Subject: FW: Invalid Planning Application - DC/24/00658

Please find attached invalid letter relating to planning application - DC/24/00658 - Oak Tree Farm, Debenham Road, Kenton, Stowmarket Suffolk IP14 6JZ

WEST ELEVATION / SECTION FRAME A-A

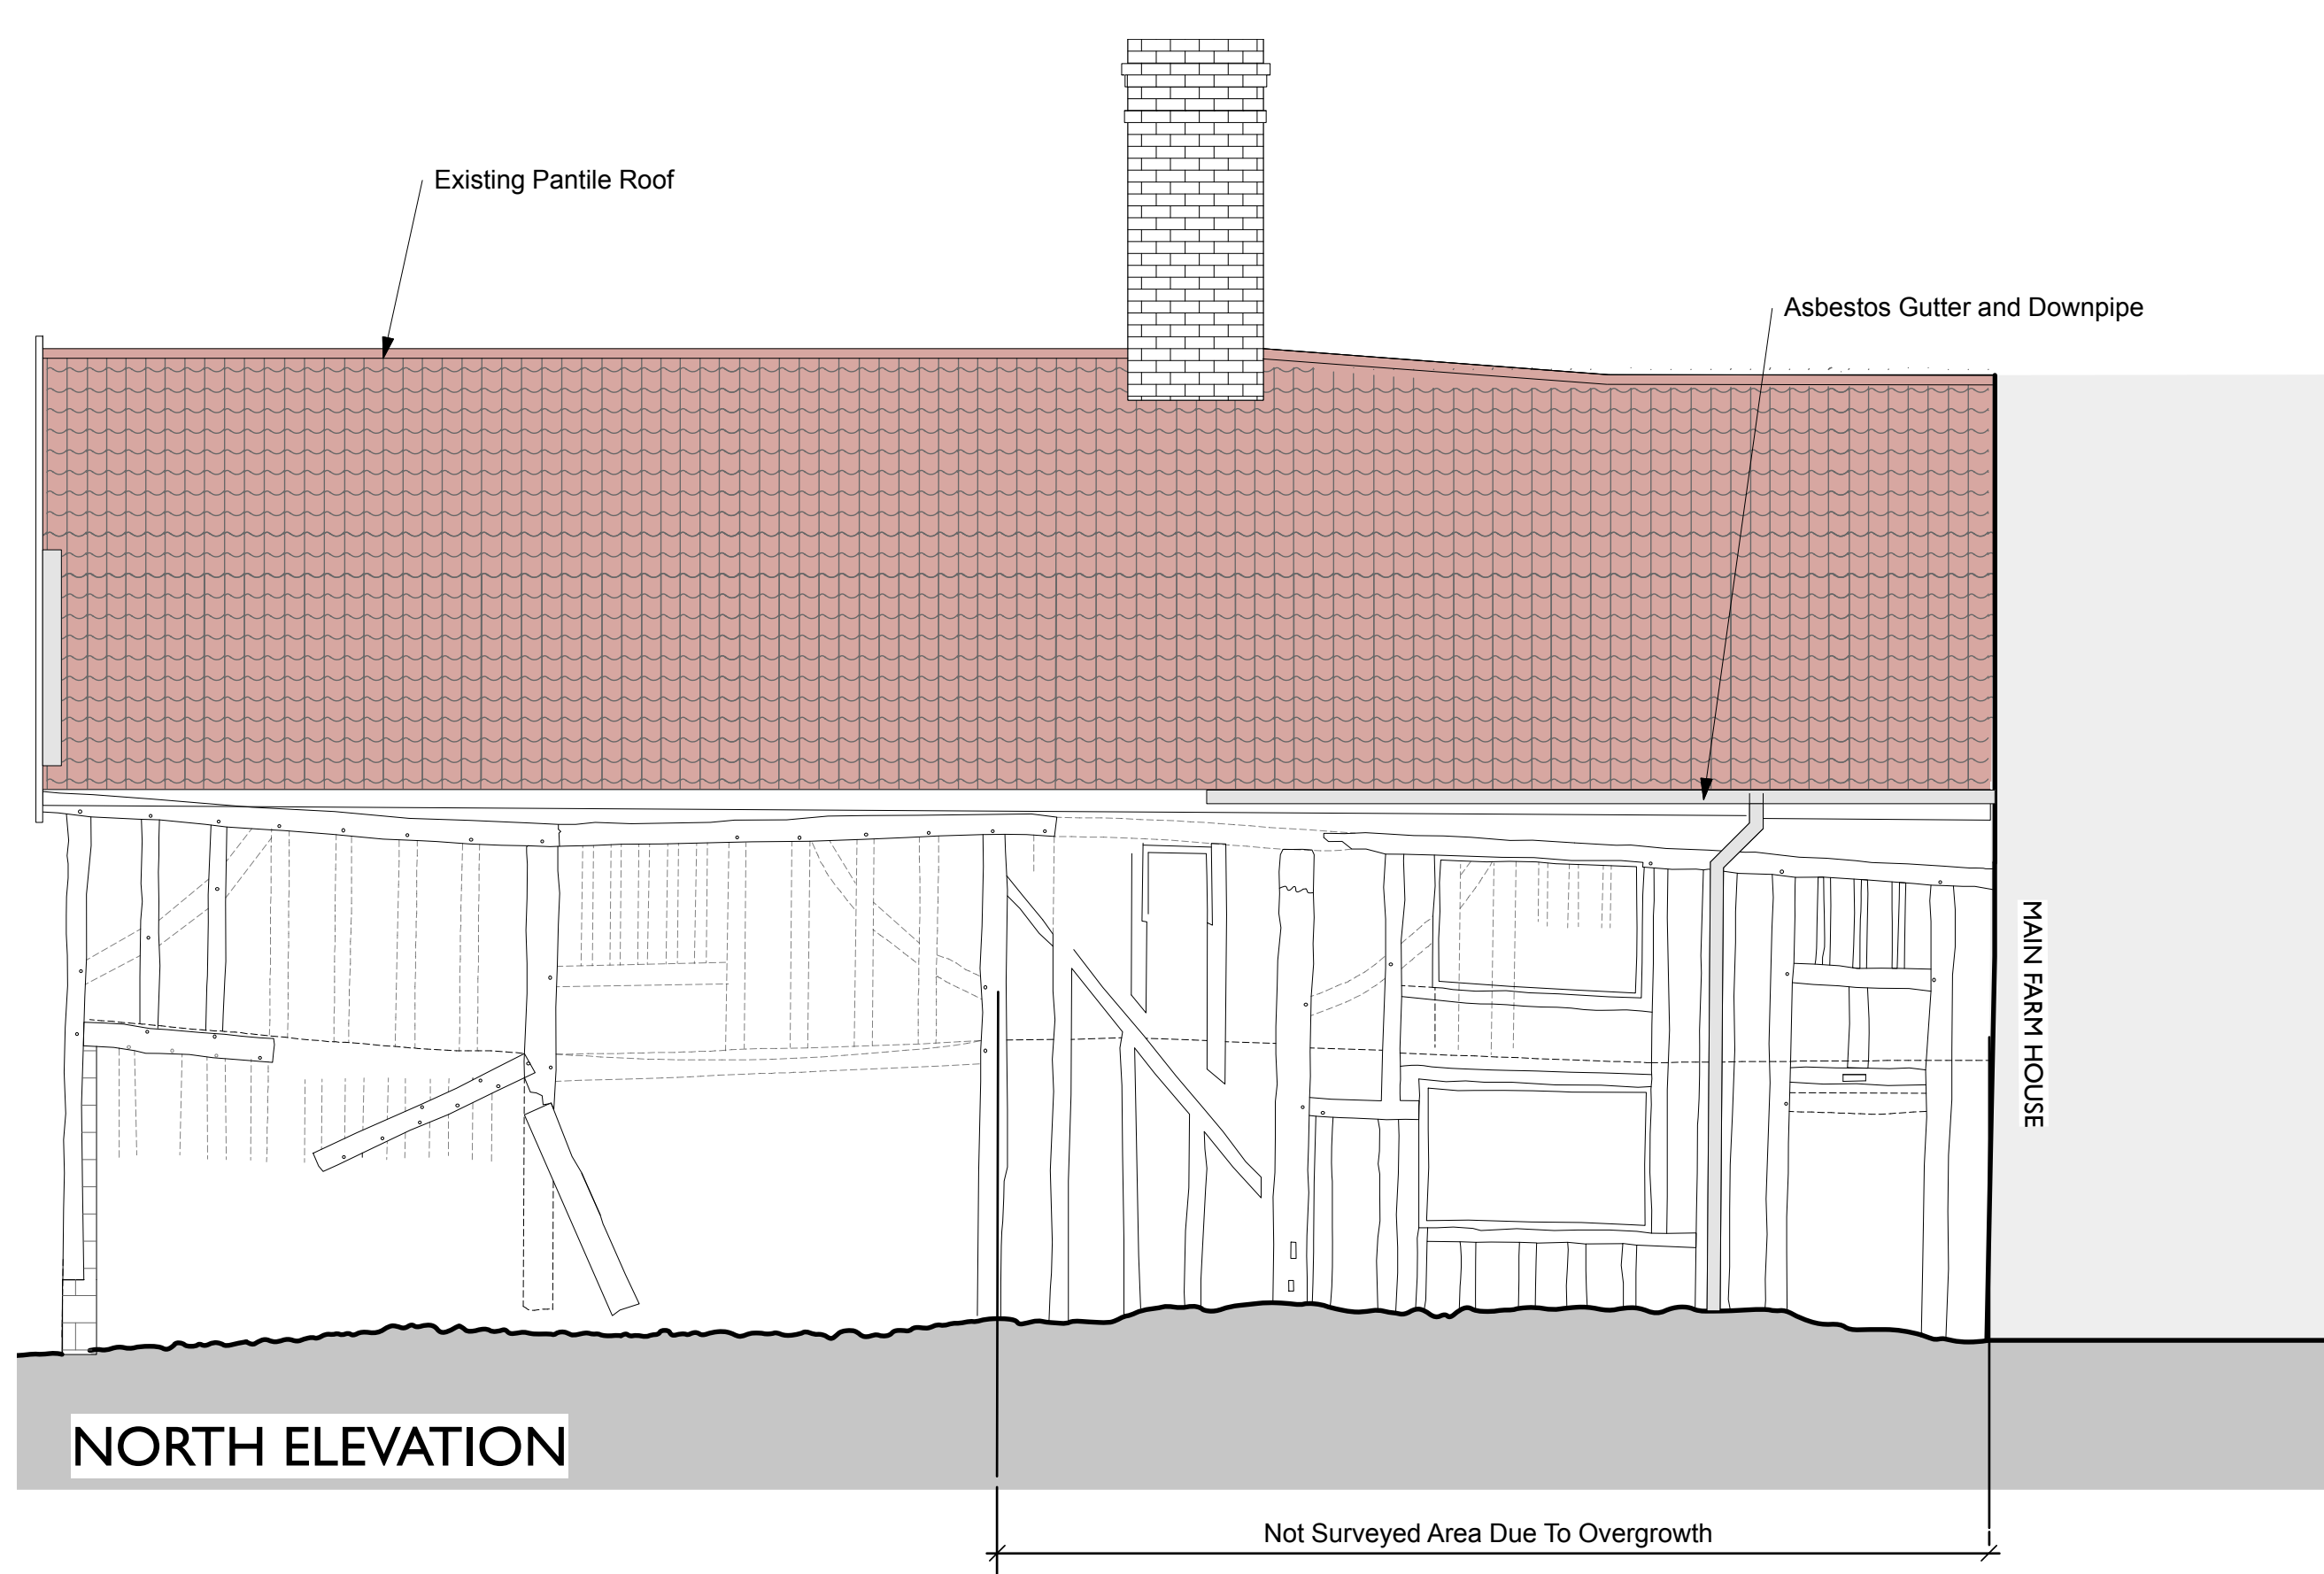
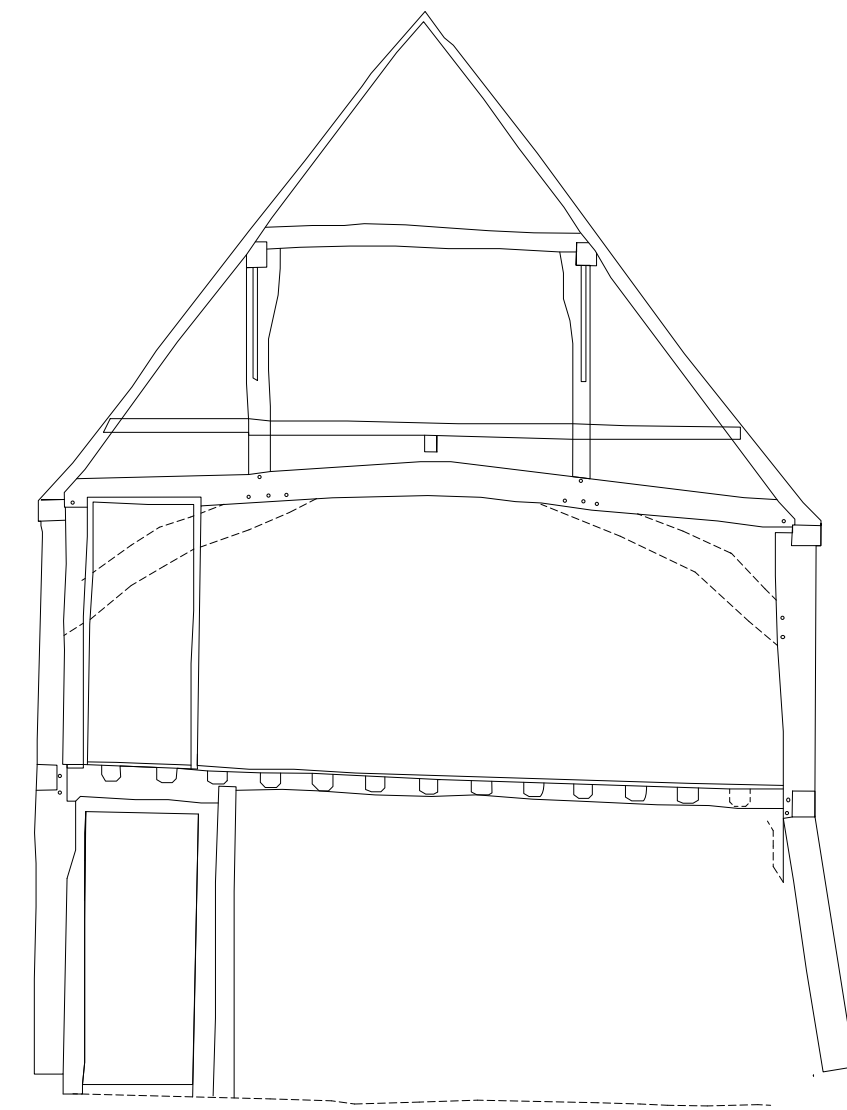
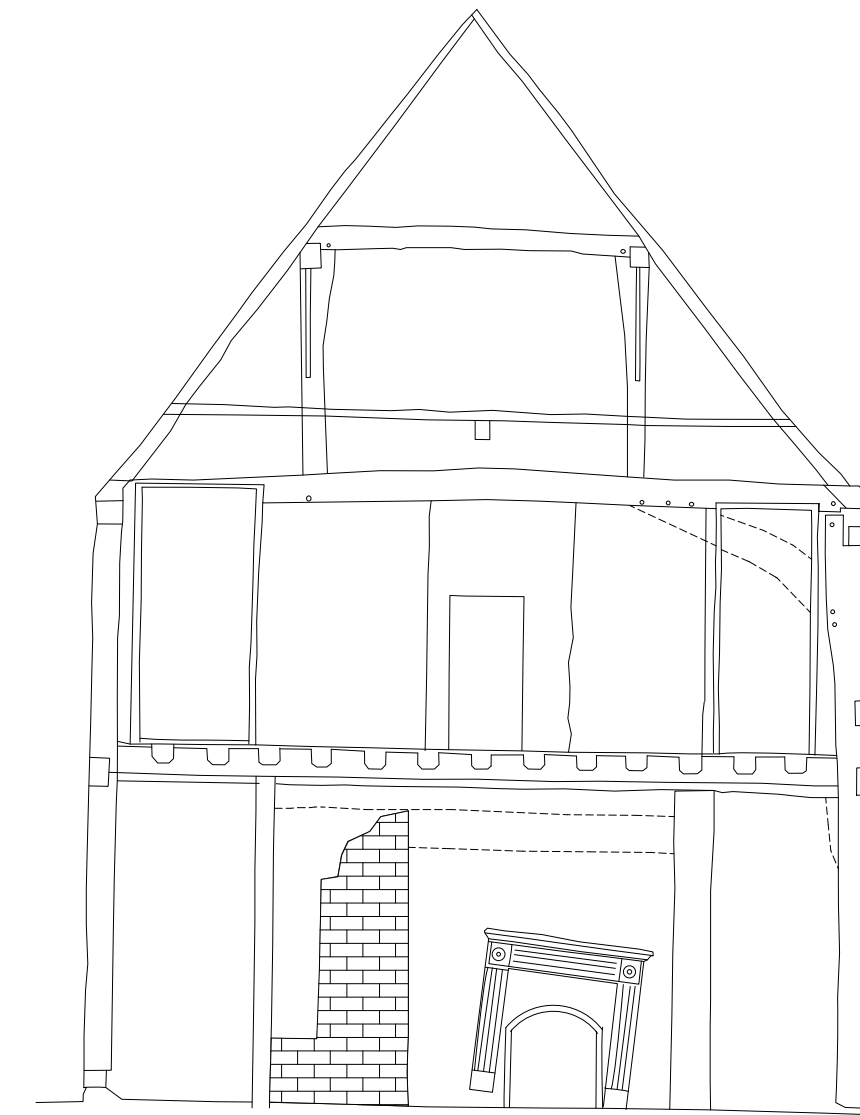
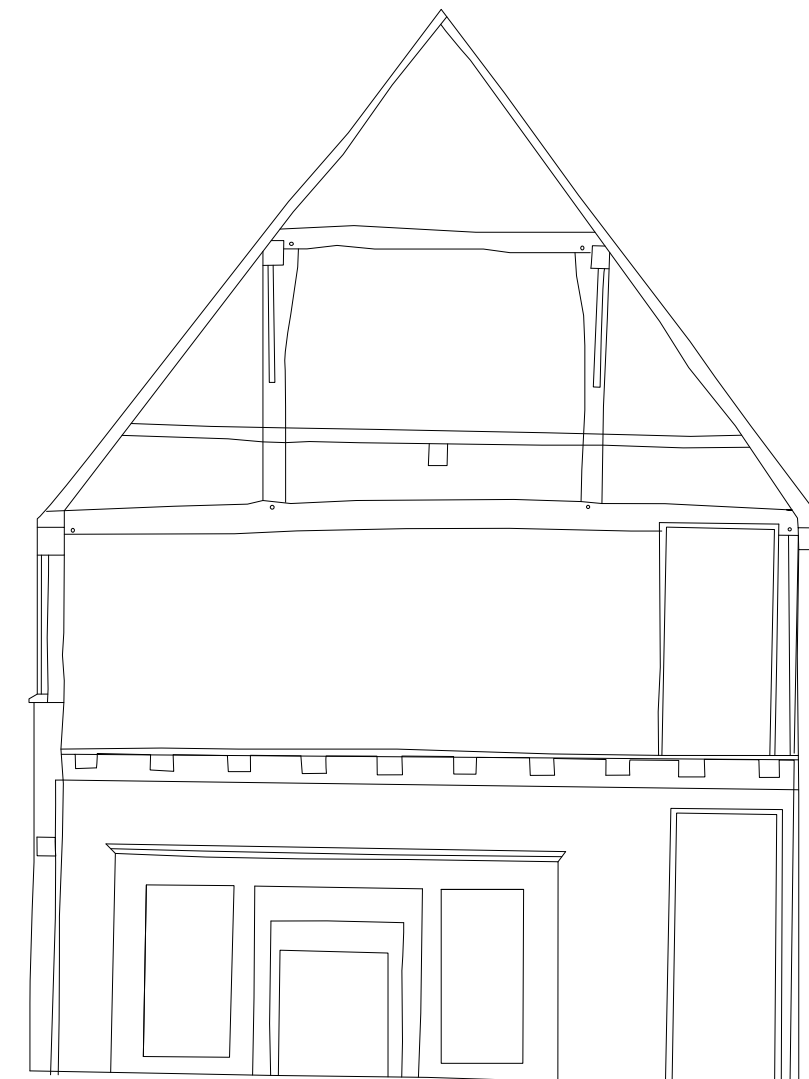
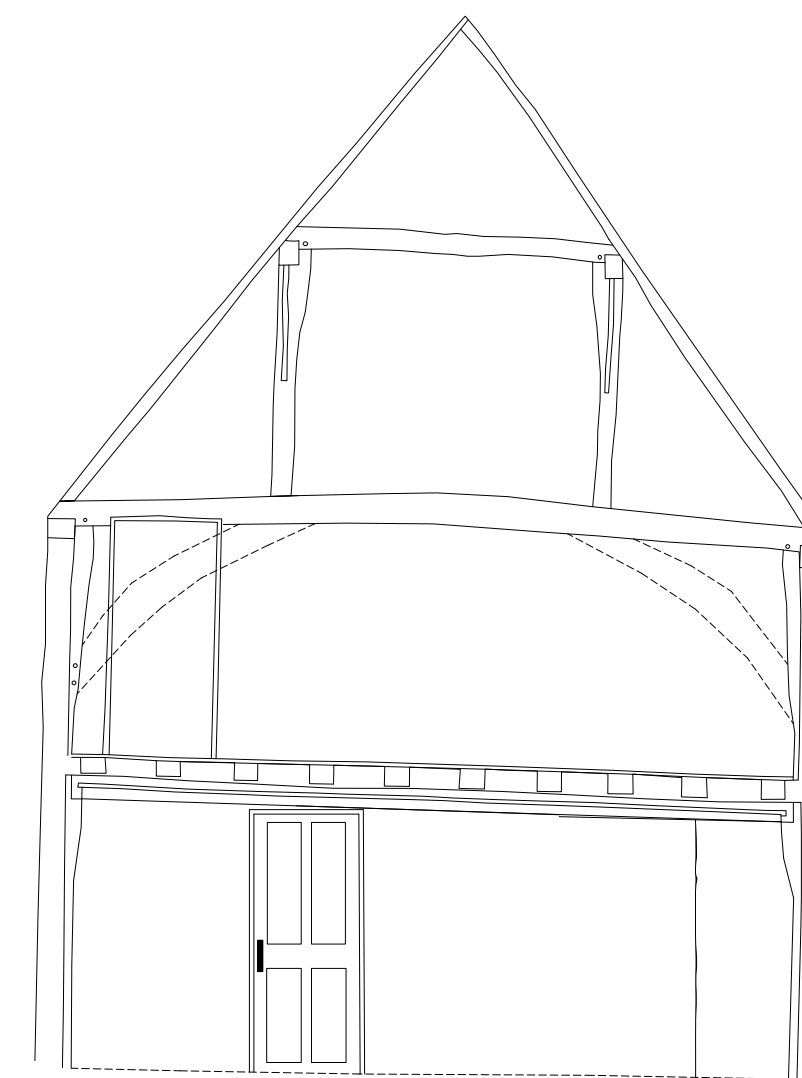
4. Although you have provided a Frame Drawing, it does not show a key as which frames are to be replaced. It maybe those showing red but that would be an educated guess therefore please amend and re-send.

Have added a key
